Recommendation Report for Planning Permission for Works or Extension to a Dwelling

REF NO: LU/121/19/HH

LOCATION: 3 Granary Way
Littlehampton
BN17 7QY

PROPOSAL: Proposed single storey rear extension.

Date:	Scale:	Paper size:	Dwg No:
Mar. 2019	As shown	A3	AR-139-04

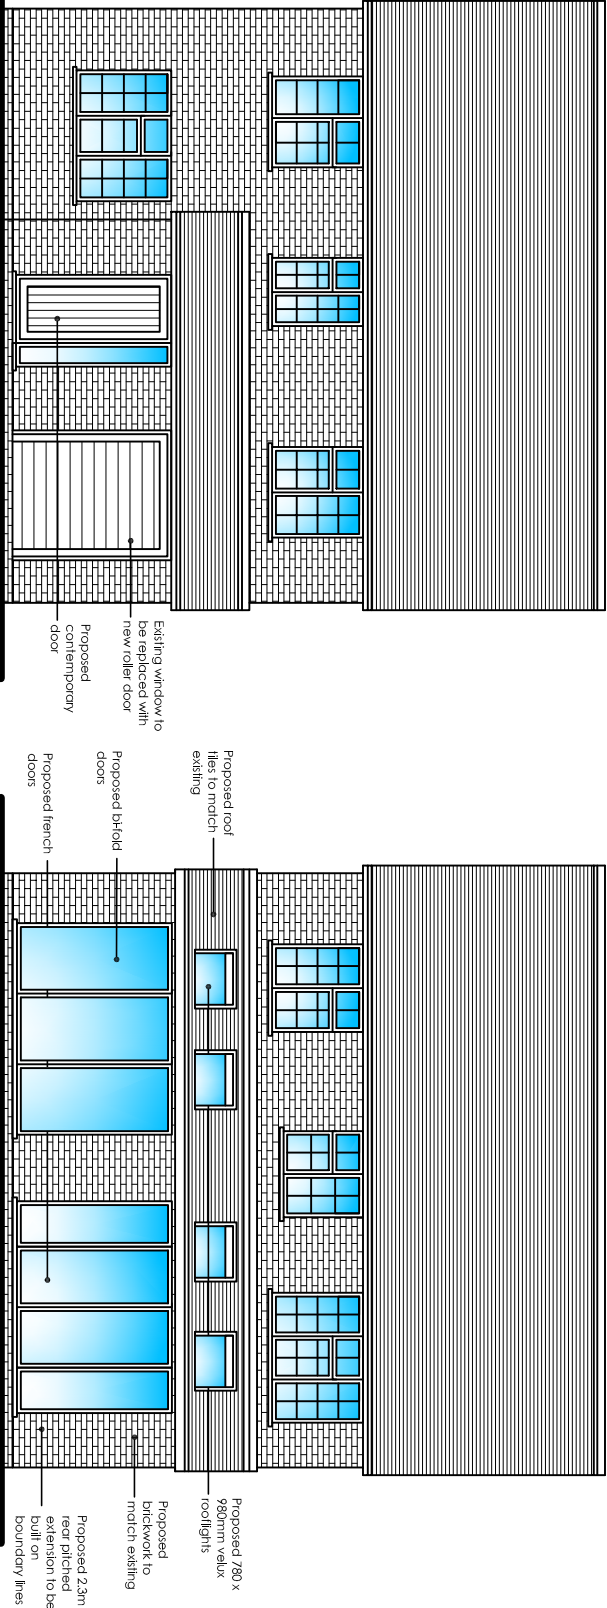
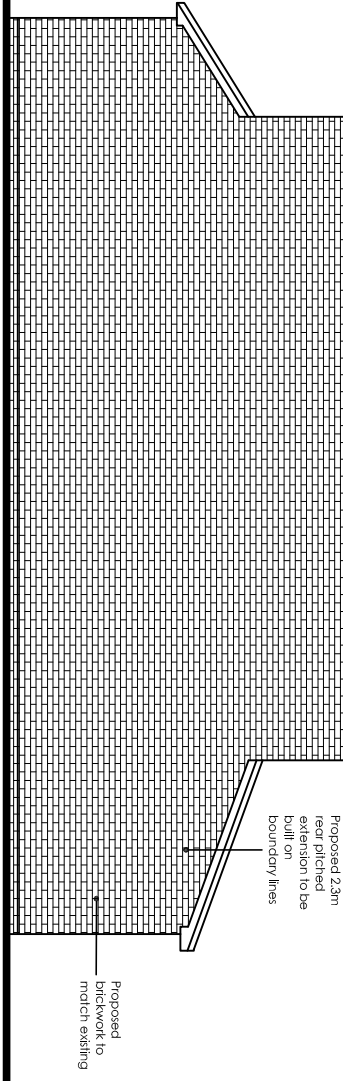
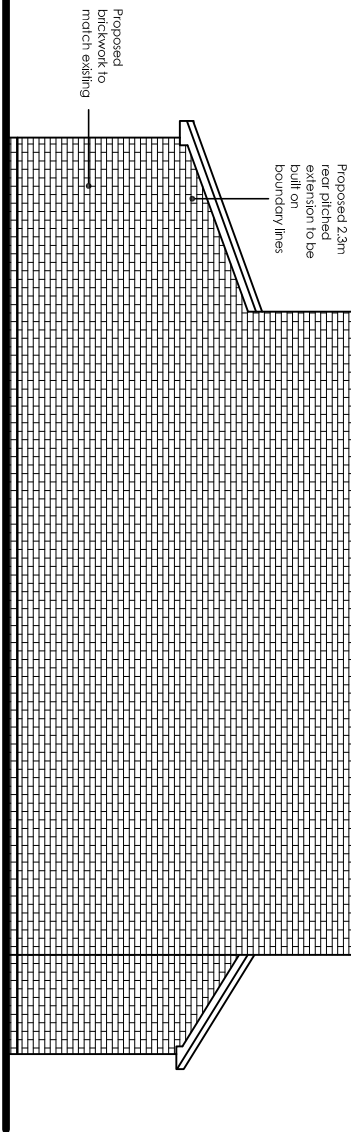
The applicant seeks planning permission for the construction of a rear extension to the established dwelling. The proposed rear extension will measure approximately 7.9m wide, 3.2m in length and be built to the proposed height at top of pitch of 3.3m and eaves measuring 2.3m.

The proposed rear extension will be located 9.2m from the north western boundary. On the northern elevation there are 4 No. proposed 'velux' windows positioned on the lean-to. There are 1 No. proposed French doors and 1 No. bi-fold doors

The 45 degree rule may cause conflict with this application but it would be modest and due to the design of the extension and its modest width and height it would not cause demonstrable harm to the amenities of the neighbour.
